Our ref: DOC21/459286

Your ref: SSD-10269

Response to Submissions – Narrabri Underground Stage 3 Extension Project

Figure 2: : Indicative Development Footprint Disturbance Area

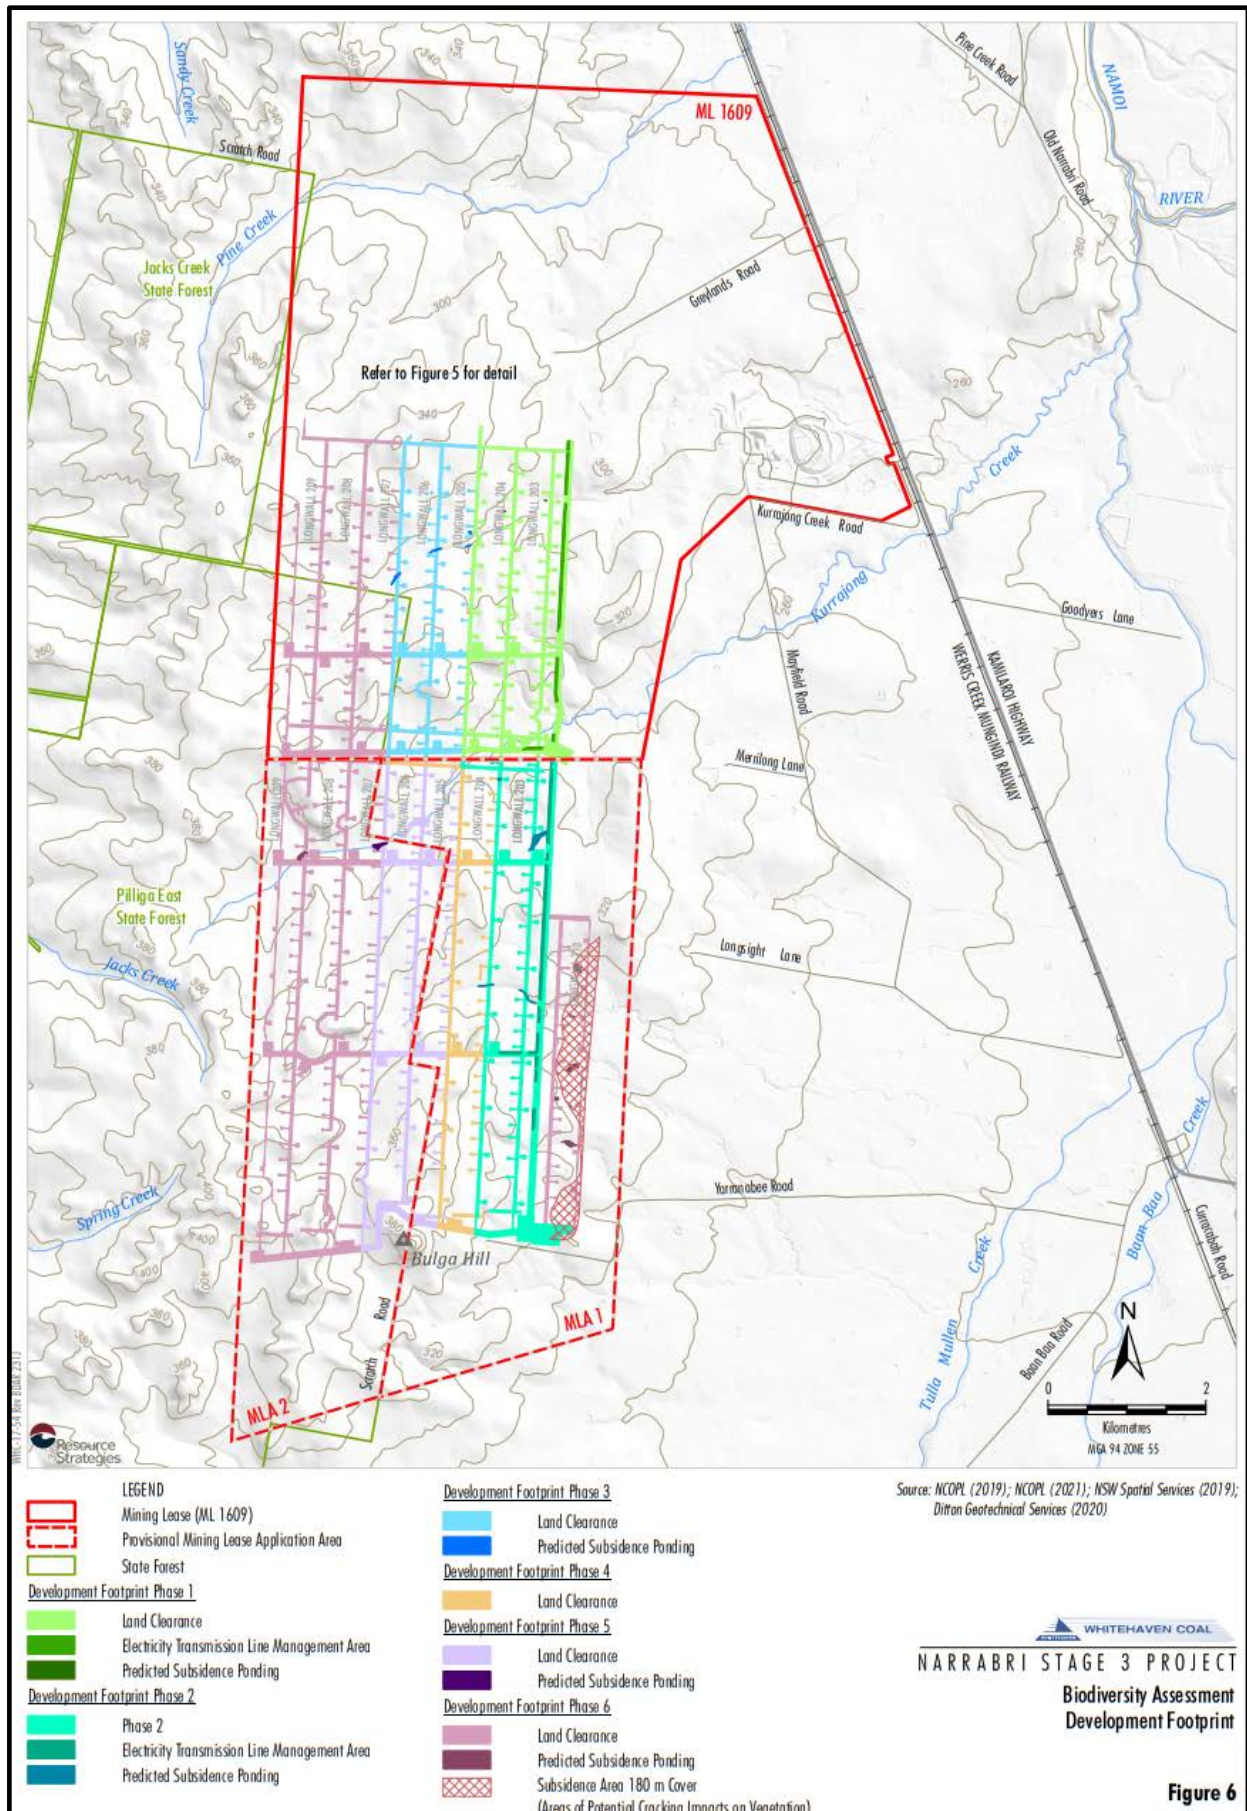
However, it is noted that the RTS report still references an indicative surface development footprint.

It should be noted that the biodiversity credit calculations for the project are quantified according to the spatial extent of the proposed development footprint. In addition, if approved, the final credit obligation calculated for impacted species and ecosystem credits will be stated in the development conditions for the project.

As the credit obligation will be identified in the approval conditions, it is BCS's expectation that any later changes to the project footprint which result in the impact to biodiversity values exceeding that or additional to that within the development conditions, would require a modification to the

approved project. As such, it is recommended that the upper quantum of likely impact required for the project is calculated when preparing the revised BDAR.
